SUNNICA ENERGY FARM

REF: EN01016 DRAFT DEVELOPMENT CONSENT ORDER

**WRITTEN SUMMARY OF ORAL CASE FOR EAST CAMBRIDGE
COUNTY COUNCIL & CAMBRIDESHIRE COUNTY COUNCIL**

ISSUE SPECIFIC HEARING 2

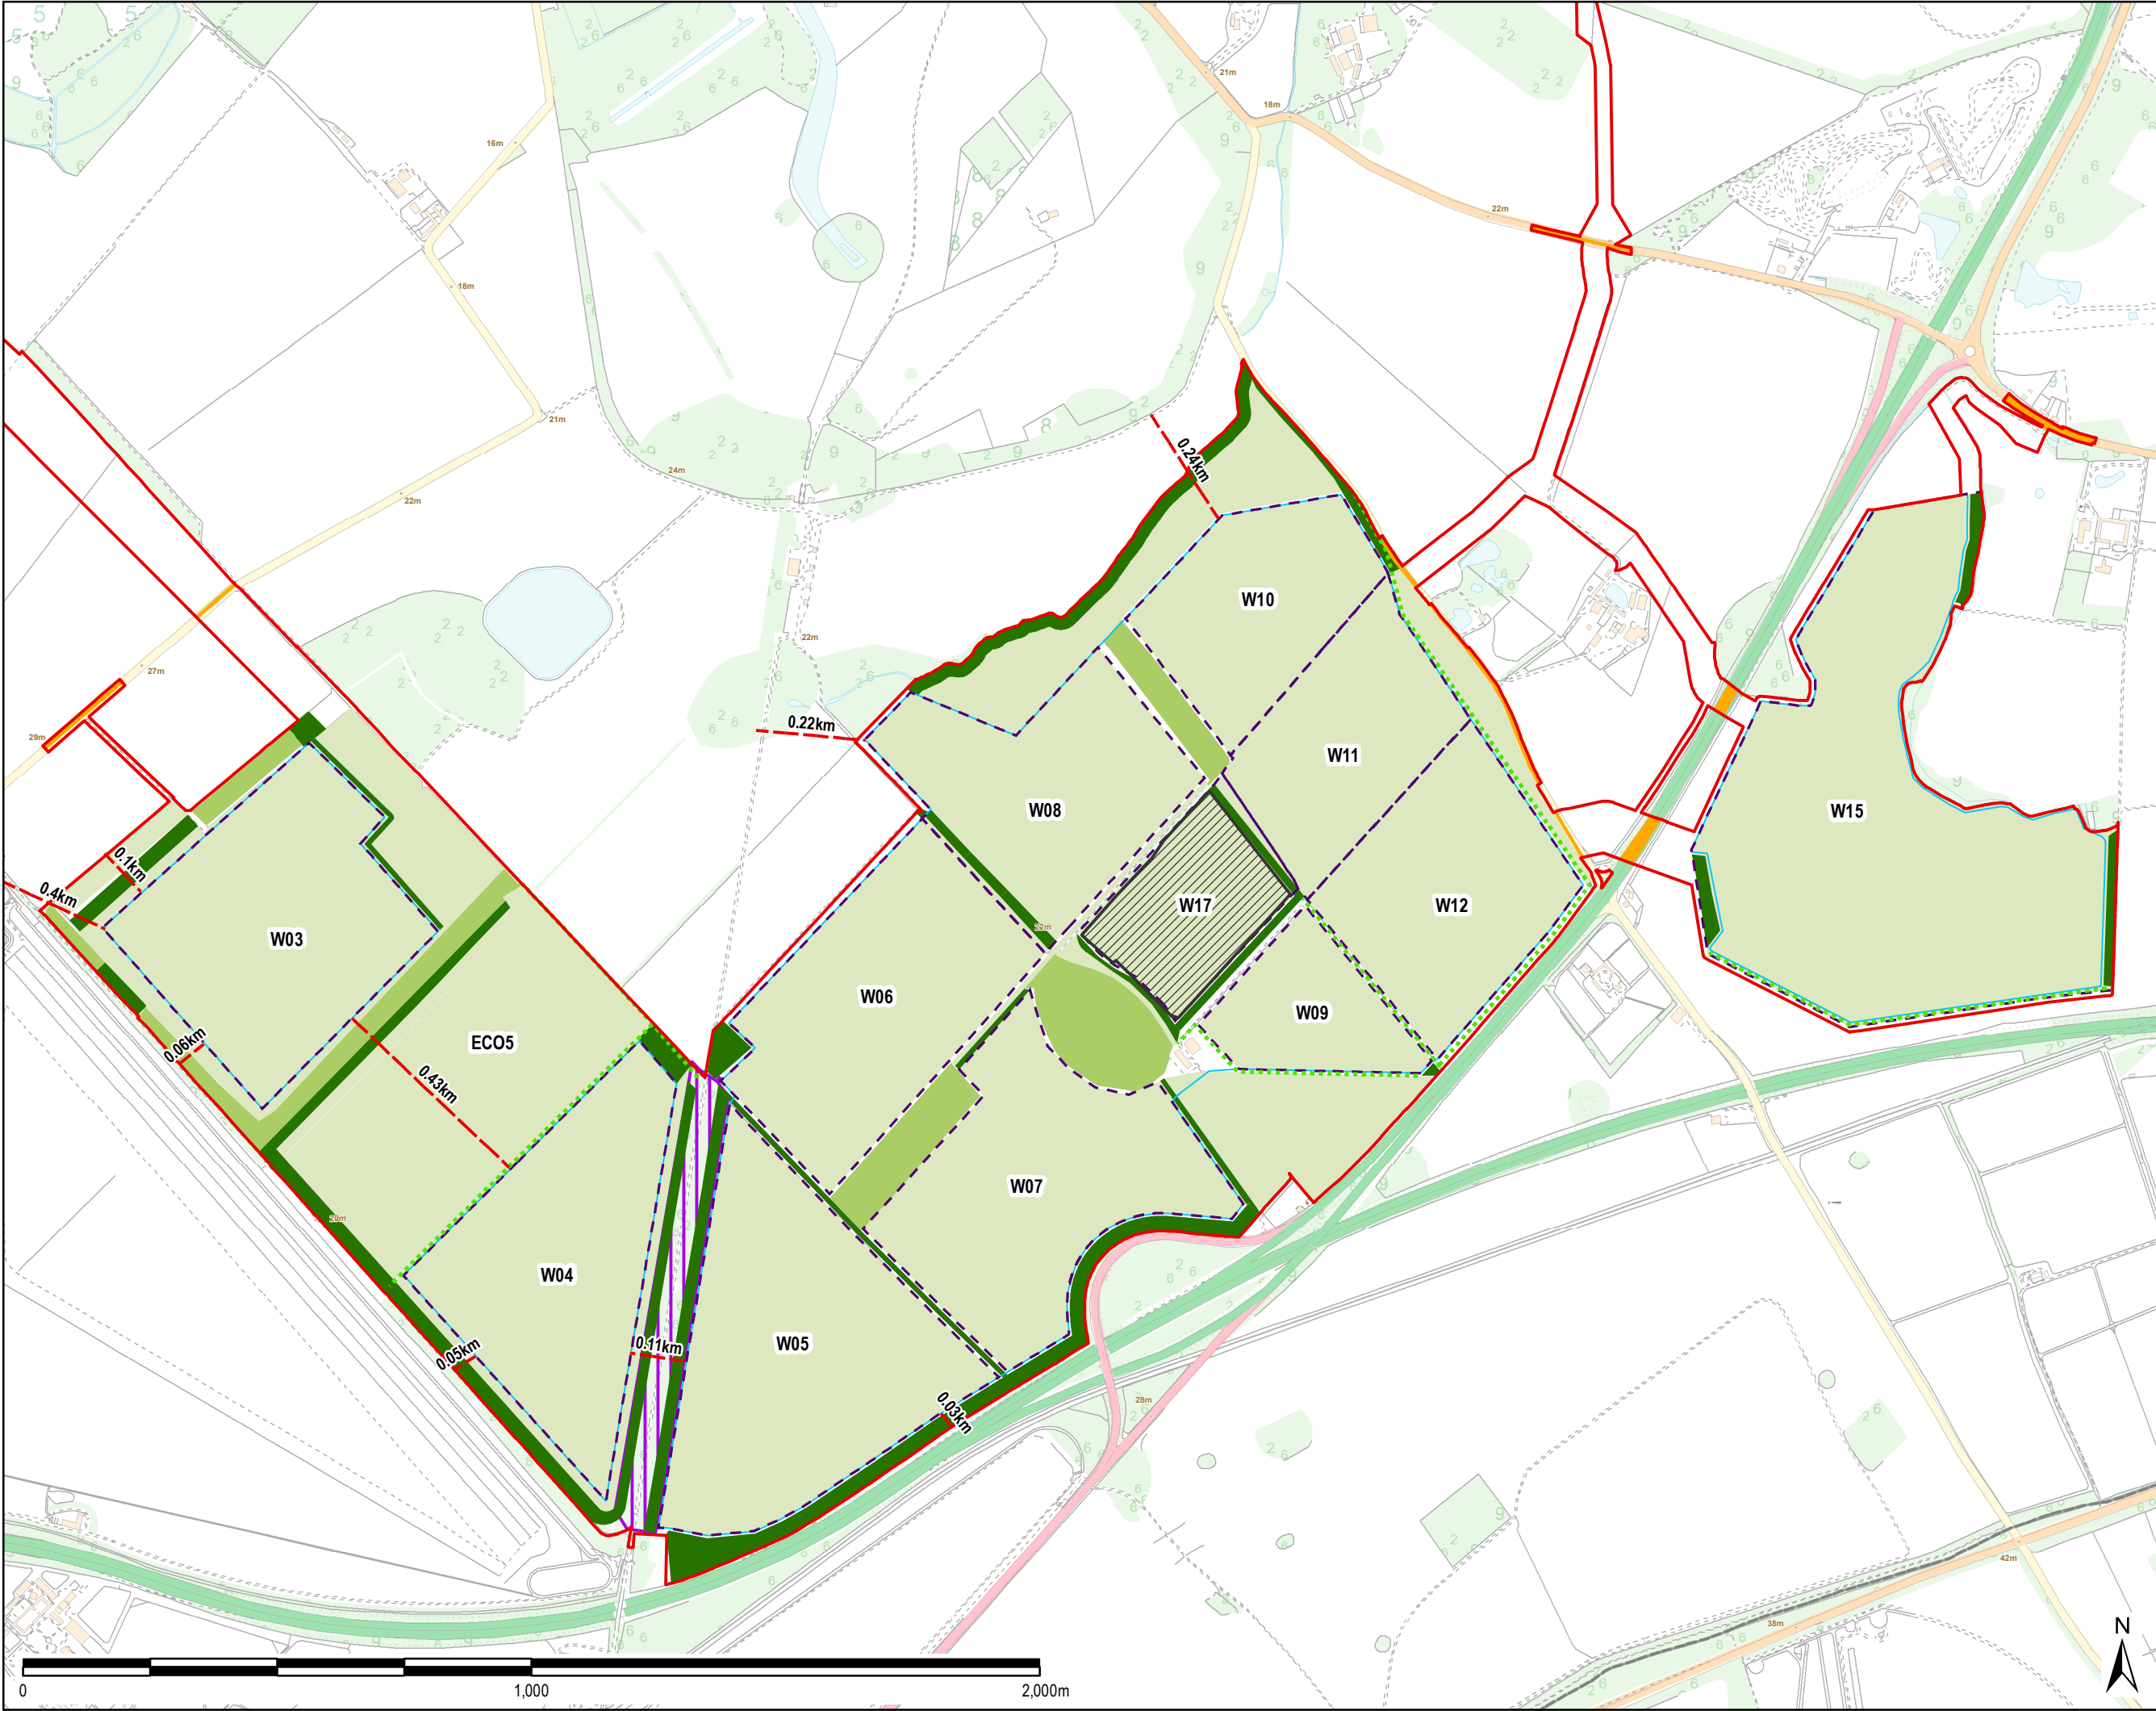
22. As a part of this, despite what has been said at the various hearing sessions, the view of the authorities remains that the only acceptable way forward in relation to landscape and visual harms is to remove parcels W03-W12 at Sunnica West A¹³ and E05 at Sunnica East A¹⁴.

31. On this item on the agenda, it is welcome that land parcels W01, W02 and ECO4 are proposed to be removed in due course. The authorities welcome this step. As to land parcels between W03-W12, W17 and ECO5 the requirement and proposal for visual screening is

irreconcilable with the constraints set out above (and orally) within the historic landscape around and within the setting of Chippenham Park. The Examining Authority should also assess the impact upon the horse racing industry here.

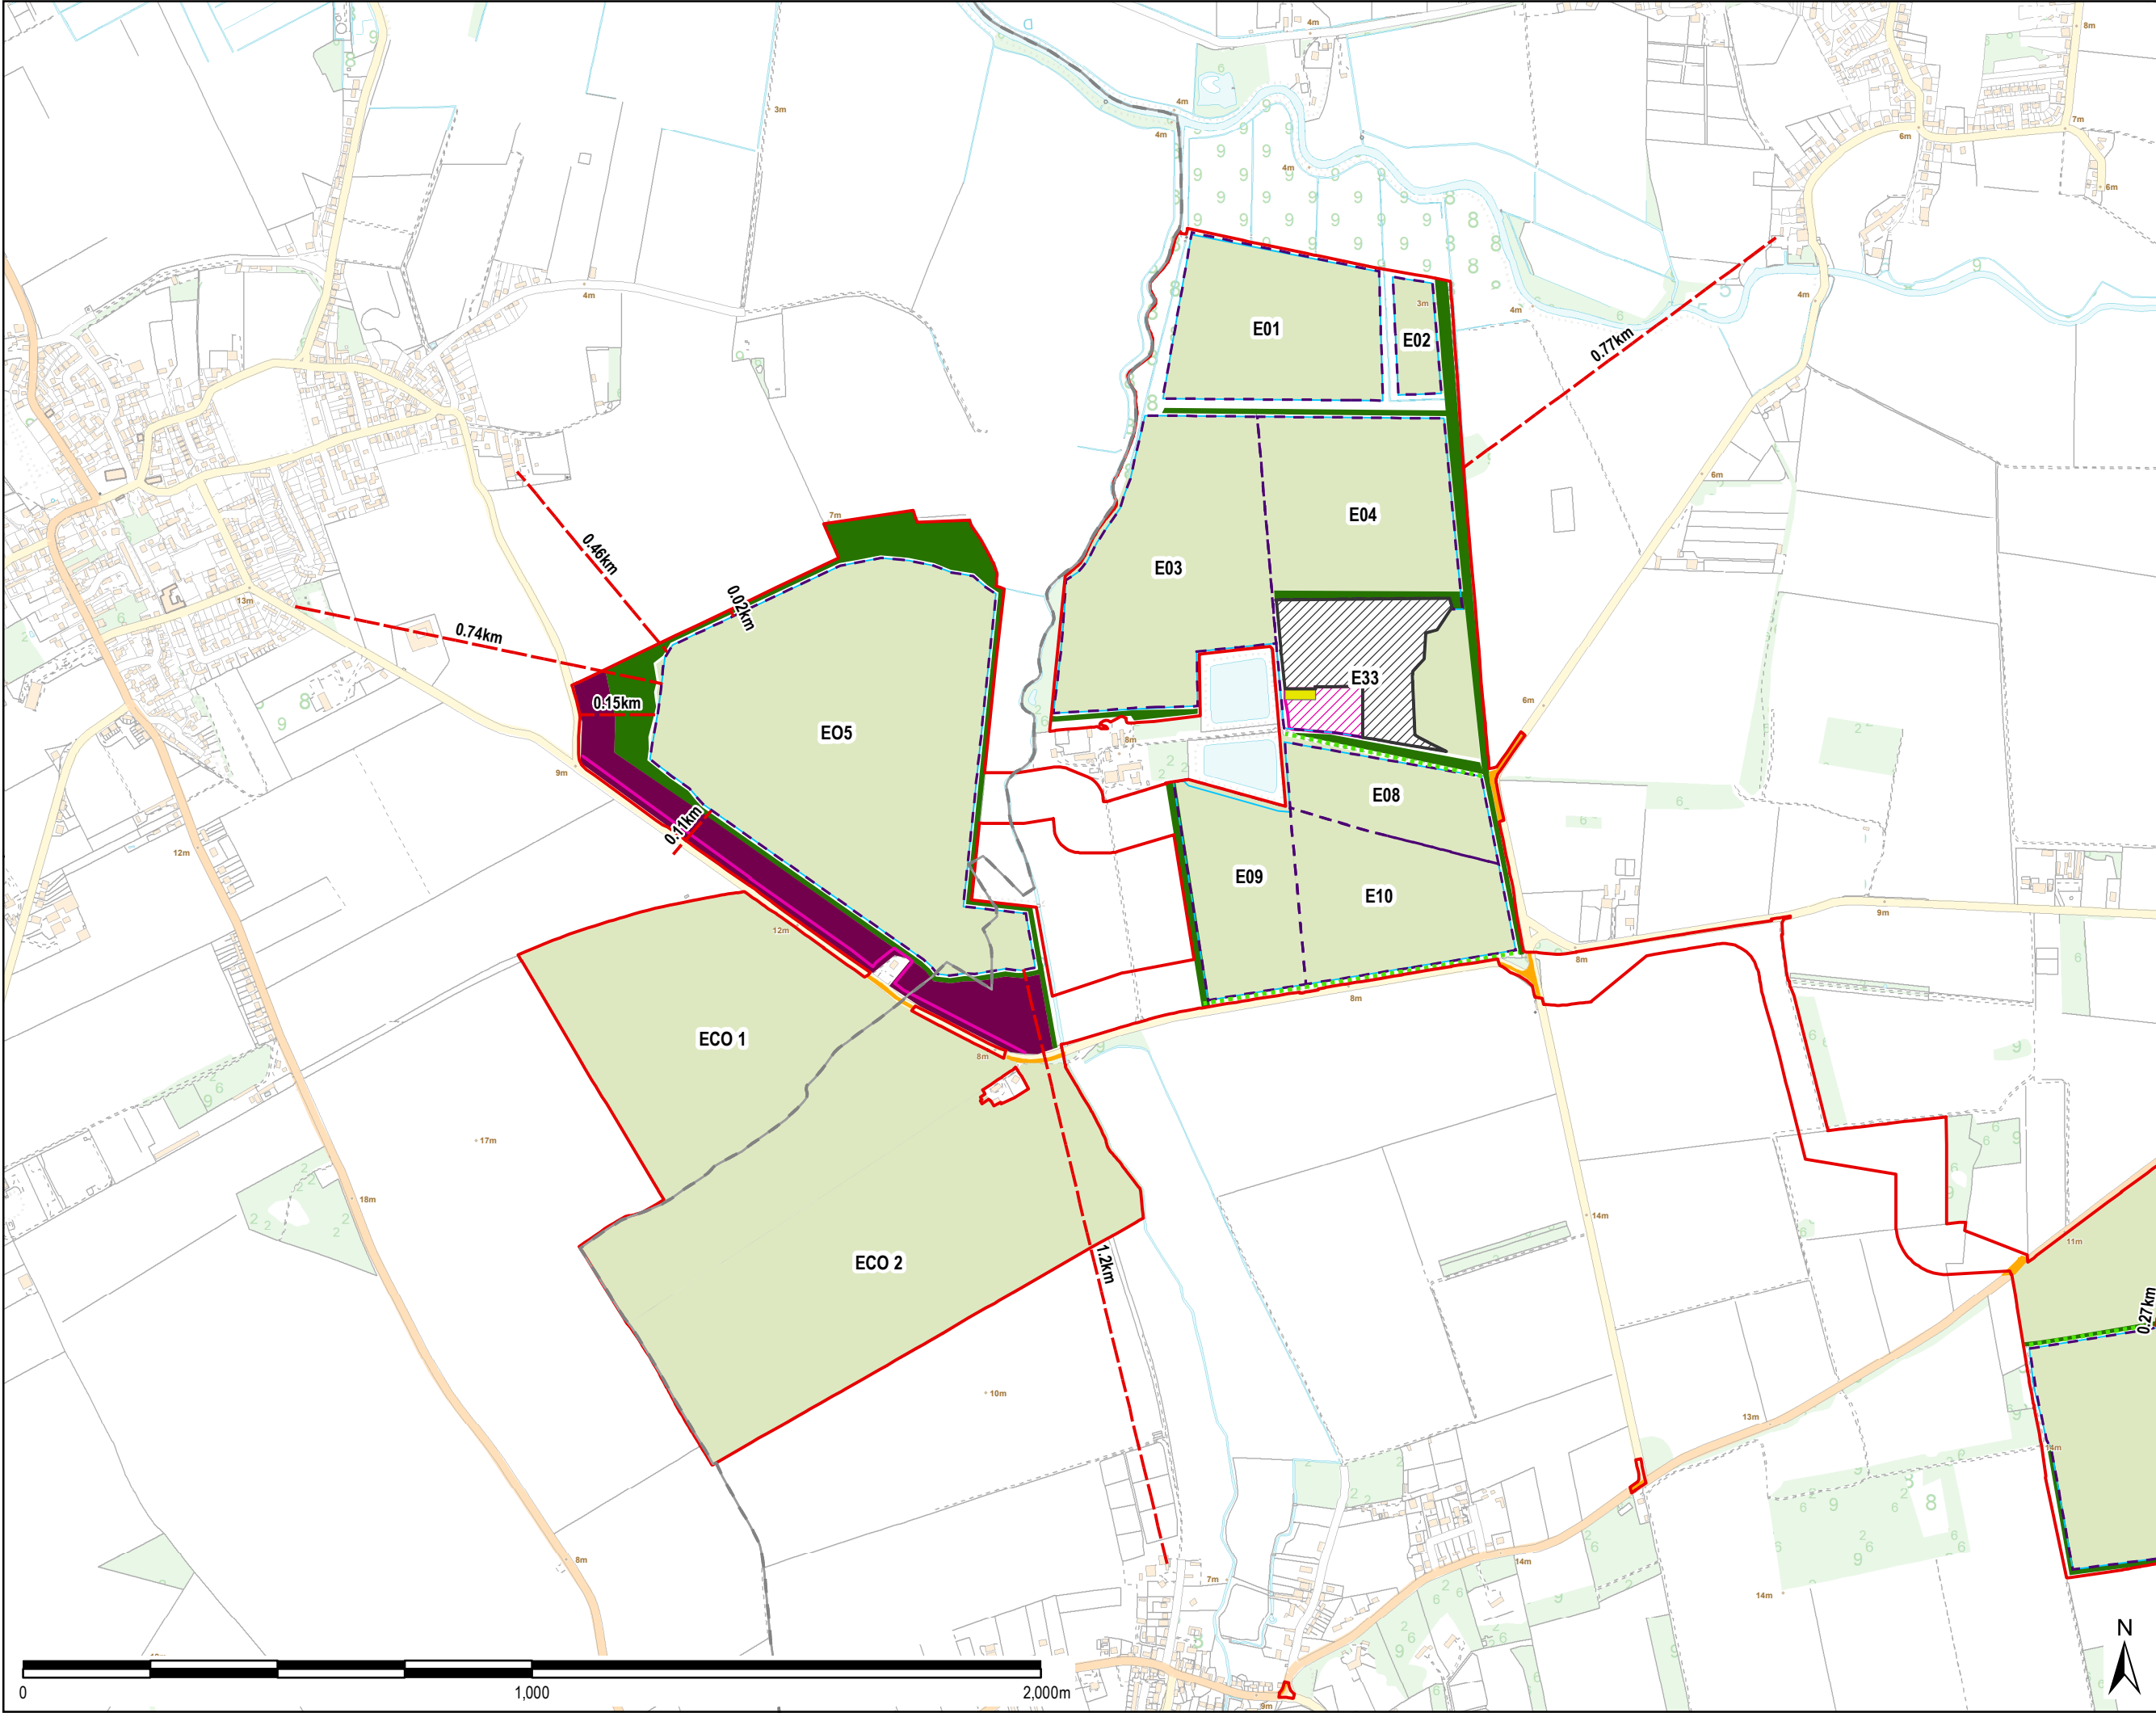
32. Within Sunnica East A, conflicting requirements for landscape, public amenity/recreation, historic environment (plane crash site) and ecology suggest the removal or substantial reduction of E05. In this respect ECDC preferred option is to apply the mitigation hierarchy and avoid harm, by removal of E05. Failing this, the Councils would request that the E05 will not engulf the plane crash site, unless the applicant can provide a strong outline design that demonstrates positive placemaking (as explained above).

33. A sound structure for Rights of Way that connects the plane crash site to Isleham, would form an essential part of such a design. It is considered that in order to achieve this the northern half of E05 has to be removed, a memorial/reflection space created adjacent to the crash site with Rights of Way connecting back to Isleham to be secured via a Public Rights of Way Mitigation Strategy. Additional Rights of Way should also benefit ecology by reducing recreational pressure of ecological sensitive mitigation areas.
